CITY OF MERCER ISLAND

RE: Request for Information #2 for File No. SUB21-008 – Koneru Short Plat
6610 East Mercer Way, Mercer Island, WA 98040; King County Tax Parcel # 302405-9153

The City of Mercer Island reviewed your second submittal for SUB21-008. Following the review of the materials, City staff has determined that additional information is necessary to ensure compliance with the Mercer Island City Code (MICC). The following items will need to be addressed at your next submittal:

KONERU SHORT PLAT (21-008)
6610 EAST MERCER WAY
MERCER ISLAND, WA 98040
PRELIMINARY SHORT PLAT

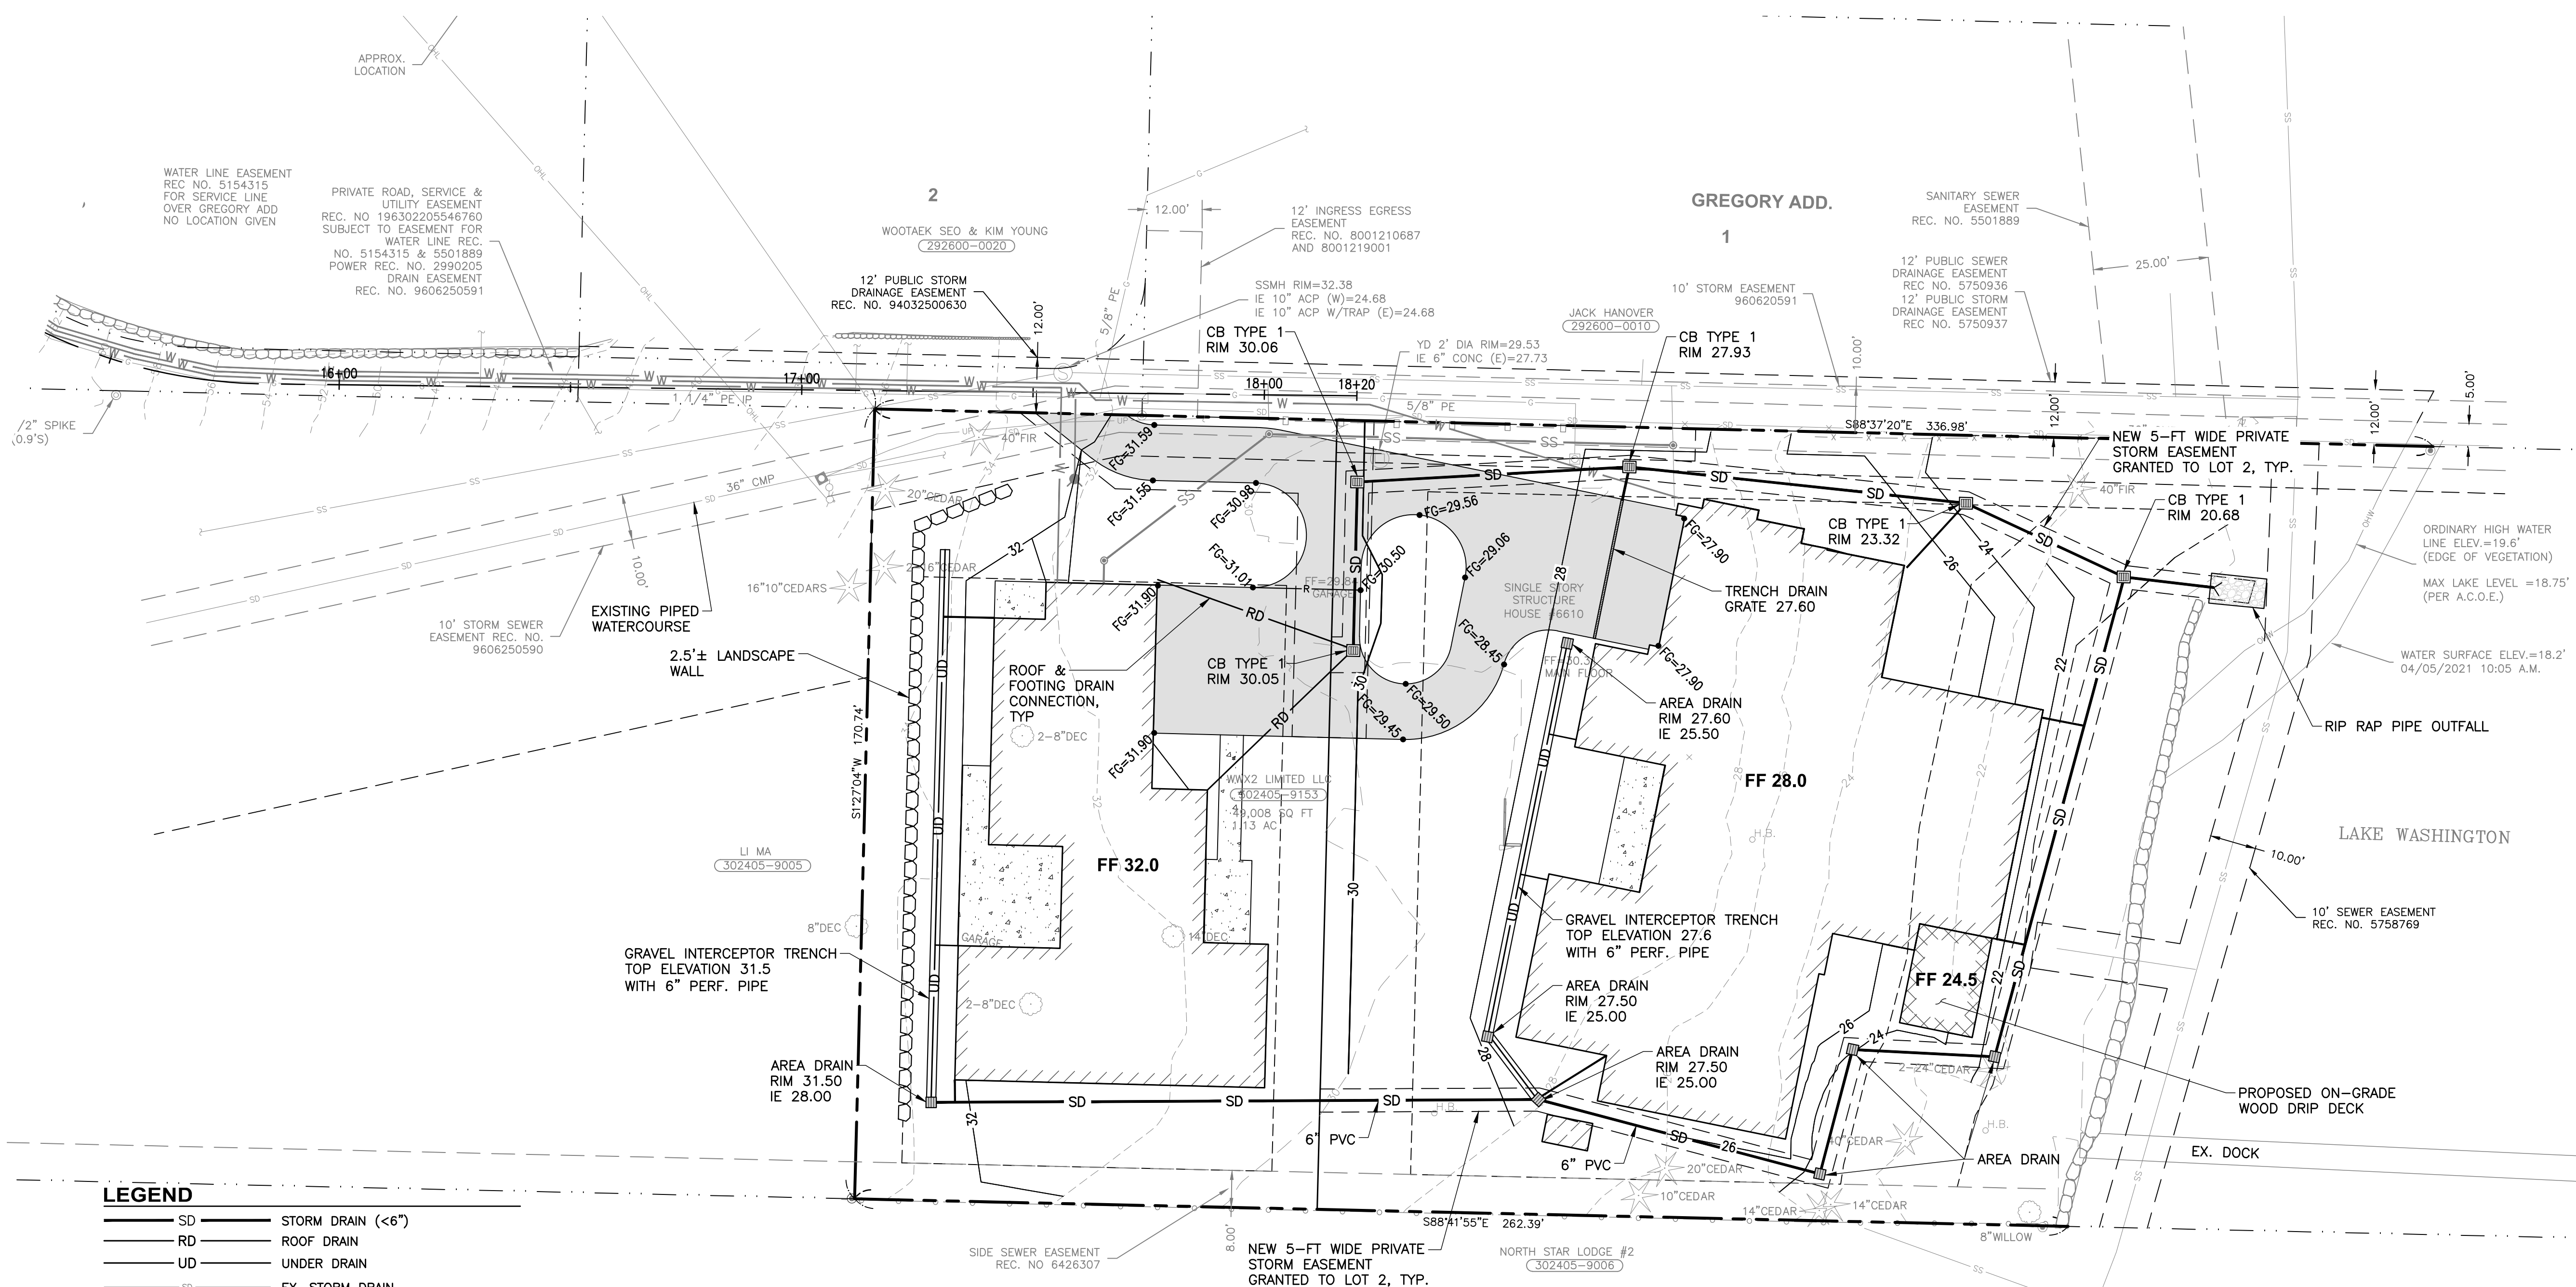
1. The plat map needs to have the statement from the fire marshals office placed on it.

“All building permits are subject to meeting current fire code requirements at the time of a complete submittal, including fire apparatus access as outlined in adopted code sections of the International Fire Code Appendix D. Fire plan reviews will be conducted at time of building permit submittal and may require additional fire protection systems /or additional fire prevention measures for building approval.”

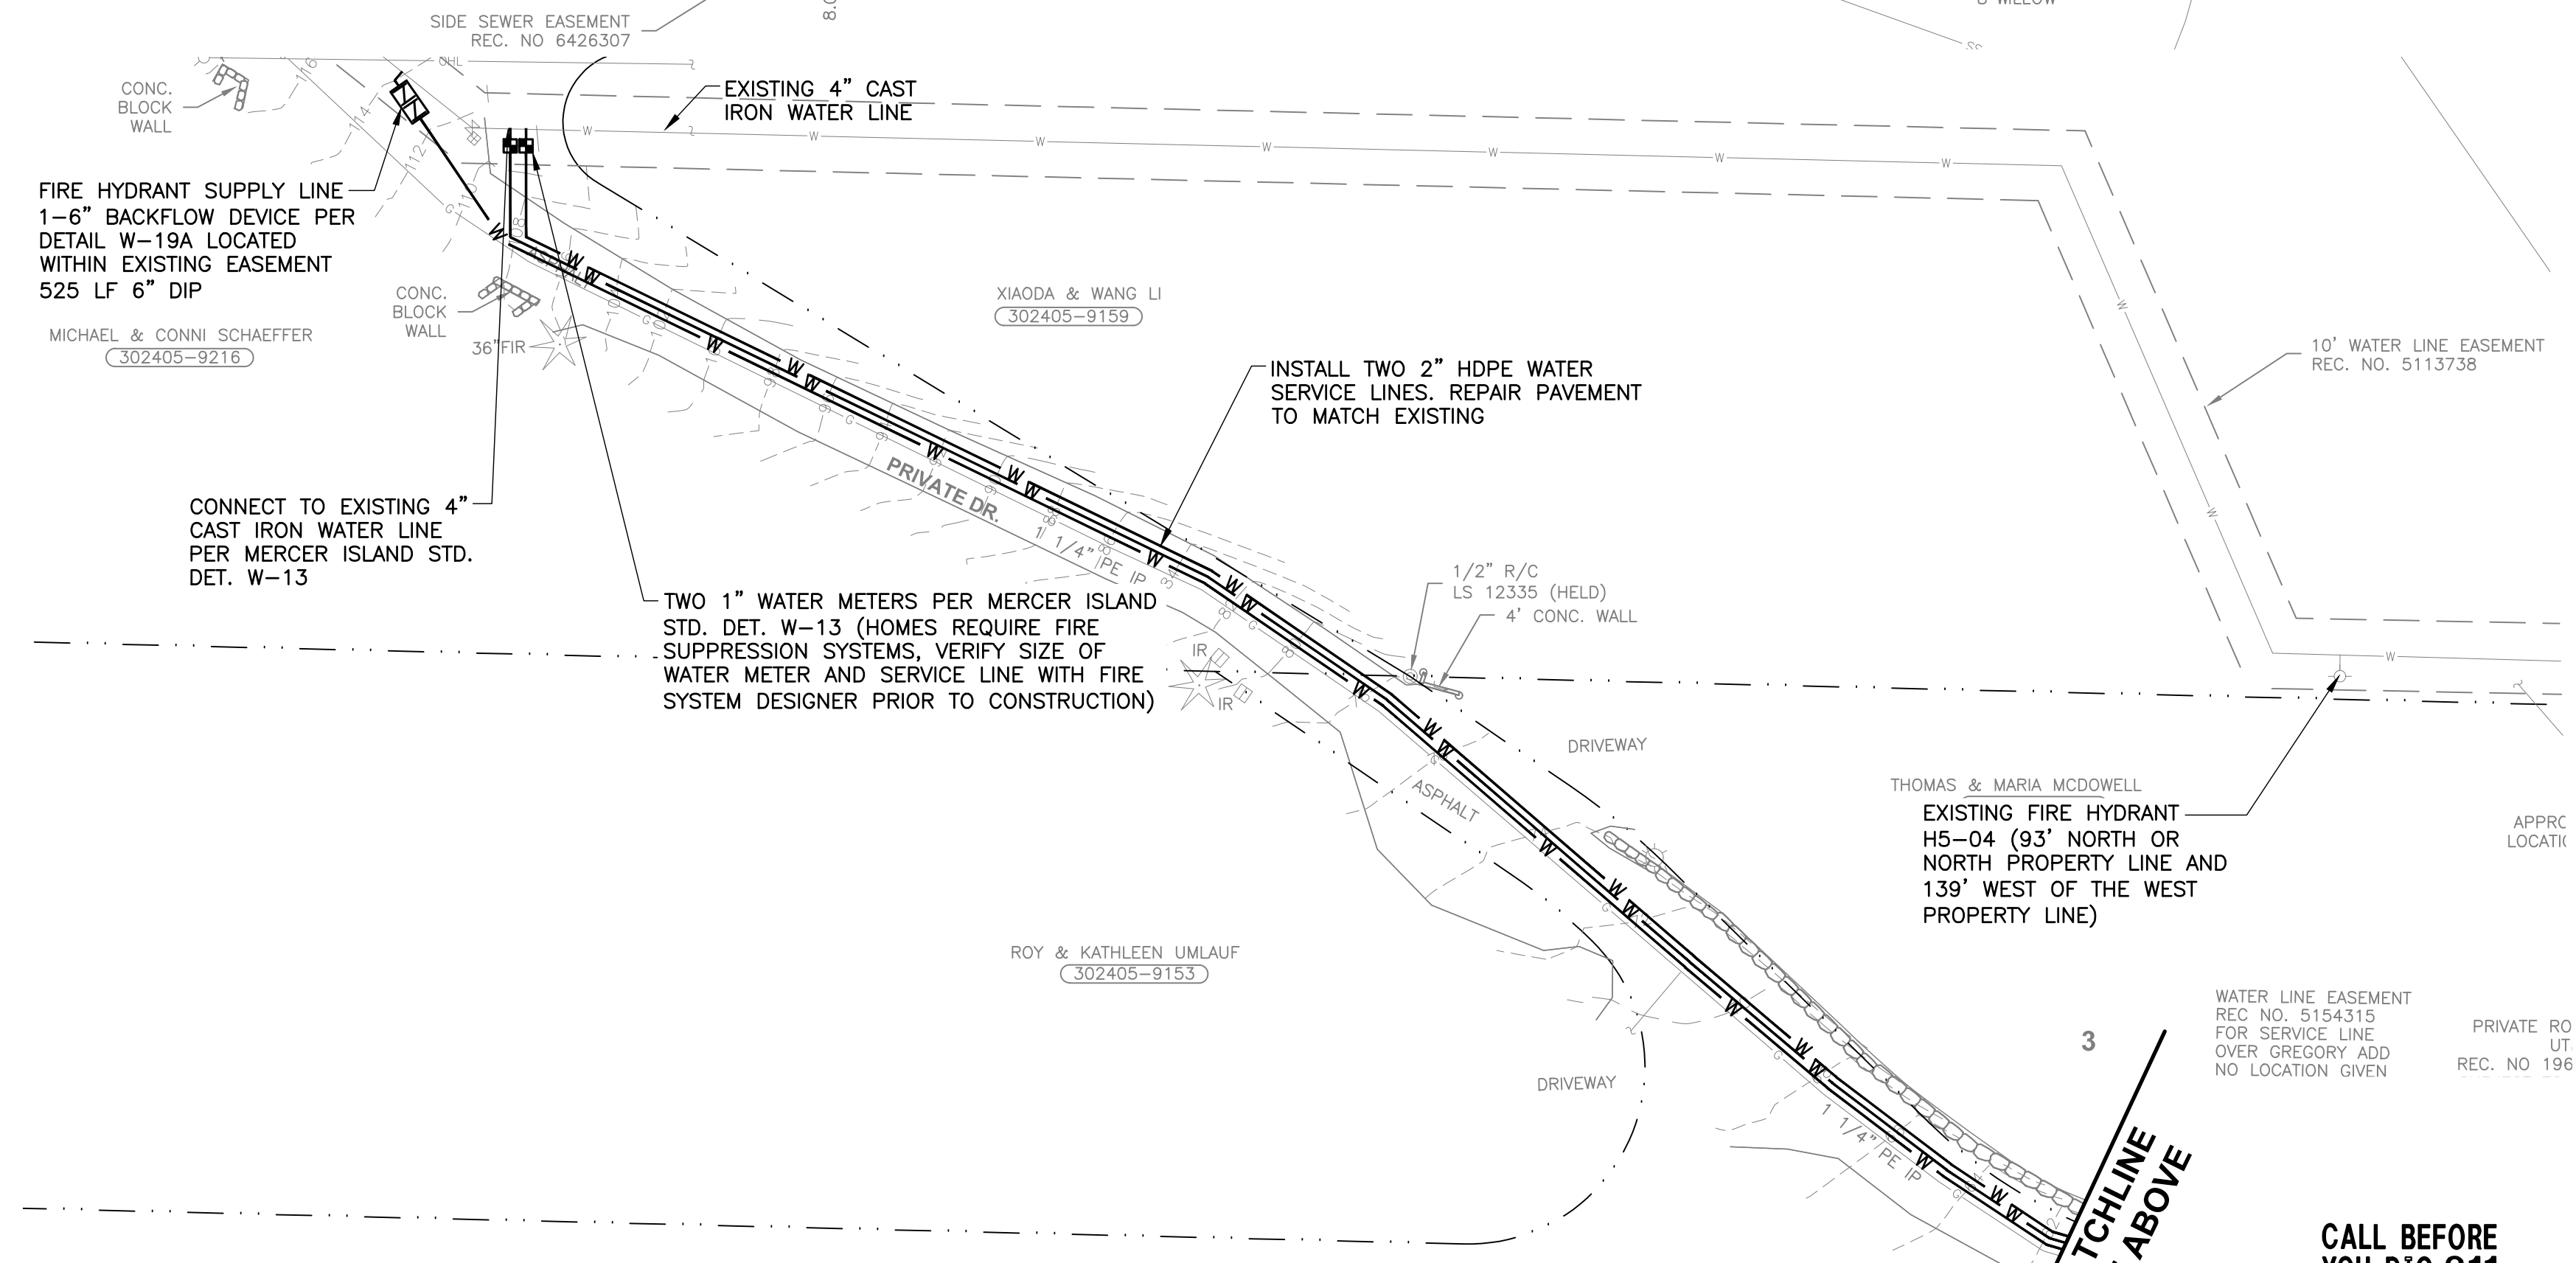
5. Future Building Permits:
 - a. For Civil and Arborist) During building plan review a tree protection plan with all Civil information must be created. Tree protection will need to be shown on C3.0. The retaining wall, trench, and other utilities to be moved outside saved trees driplines/minimum limits of allowable disturbance. The SD is shown within 9-feet of exceptional tree 576. Tree 575 also has a SD line within minimum limits of allowable disturbance. Update tree protection plan with tree protection chain link fence and all the following items in this checklist. Exceptional trees must be retained according to 19.10.060.3, and protected under 19.10.080.

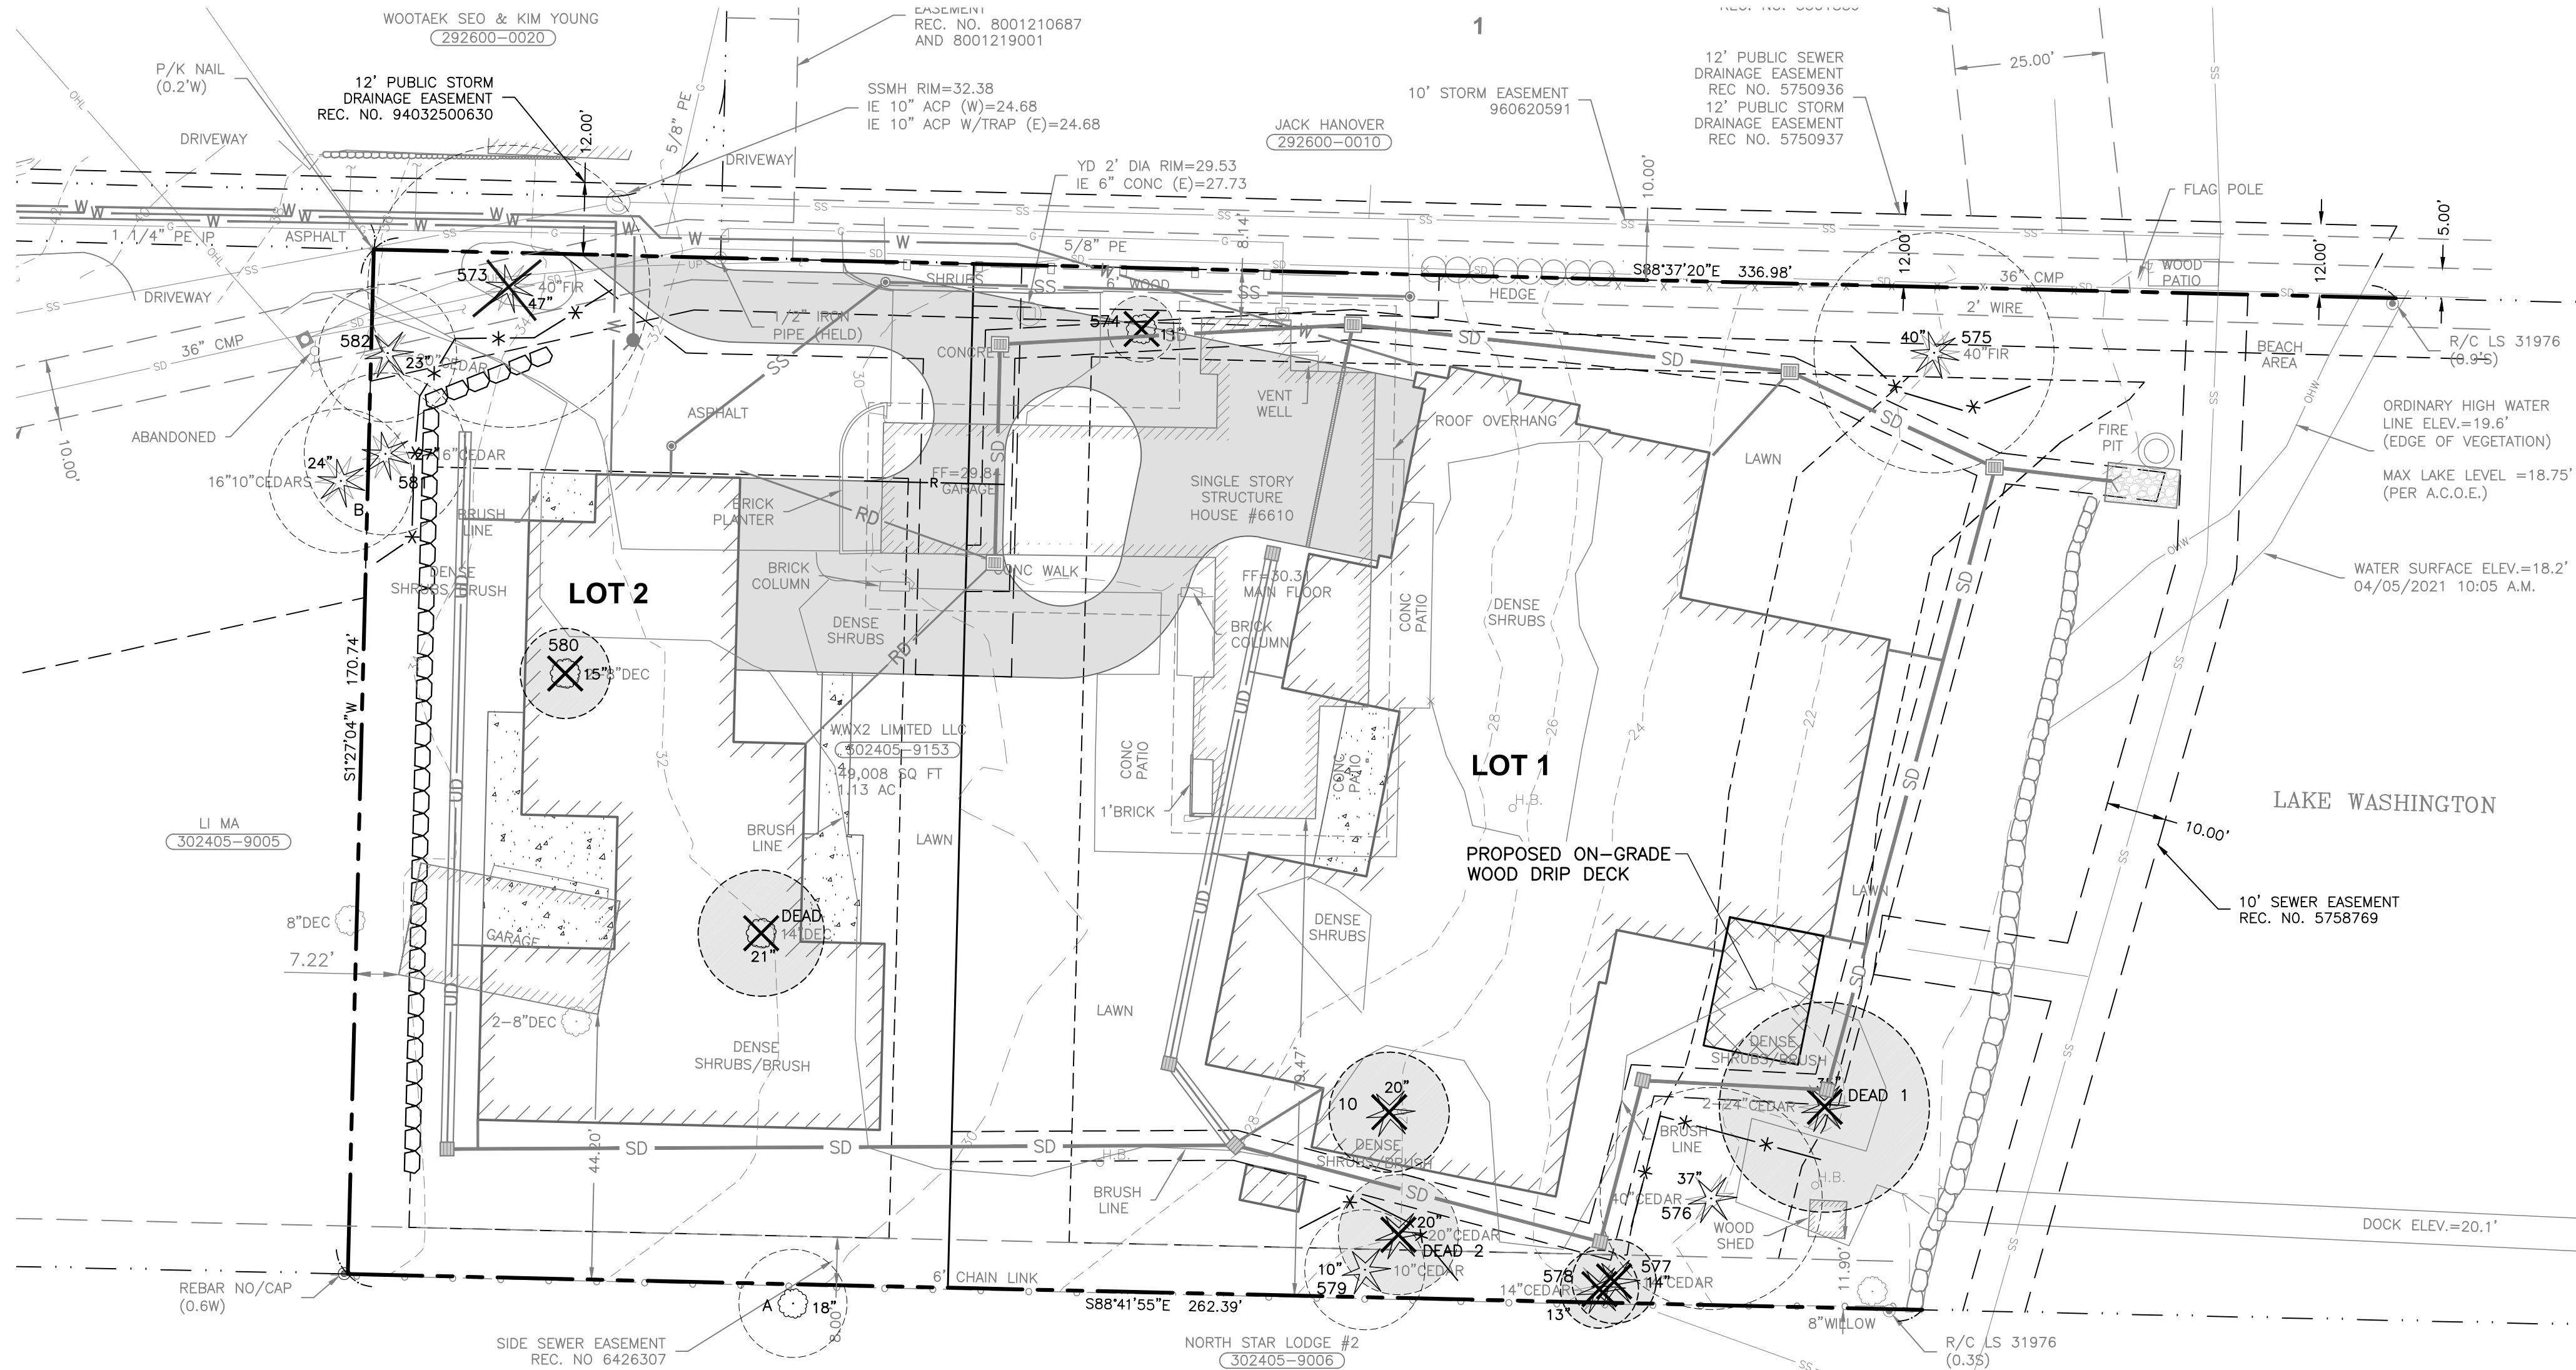
1. (Repeat comment for Architect/Arborist) provide Arborist evaluation that Dead Tree 1 would not have been damaged with the building pads encroachment into the tree's dripline. Even though this tree was already allowed for removal under a non-development tree permit. Since the tree was exceptional it would have been required to be retained and not damaged by development in the tree protection zone. This minimal excavation zone for the deck will be conditioned for the building phase.

2. (Repeat comment for Architect/Arborist) Provide the tree inventory worksheet and include all trees removed within five years. This will include the trees that were approved to be removed under the non-development tree permit before this development proposal. This was for five trees to be removed under permit 2104-048 (trees 6,7,8,10,15 in previous report). The tree protection plan must show at least 30 percent of trees being protected and not damaged by construction for this subdivision to be approved.

3. (Repeat comment for Arborist) Update Arborists tree report, a draft report has been submitted. Arborist will need to review new plans and confirm the distance of disturbance is adequate and will not damage the saved tree.

4. (New comment for Civil/Arborist) because of change of plans Tree 573 is exceptional in size and now shown for removal. Fire had approved Sub 1. What has changed? The new hydrant is beyond the minimum recommended limits of disturbance. Please provide the access and hydrant requirements that conflict with the tree. Could some asphalt removal mitigate for the impacts of the new improvements?
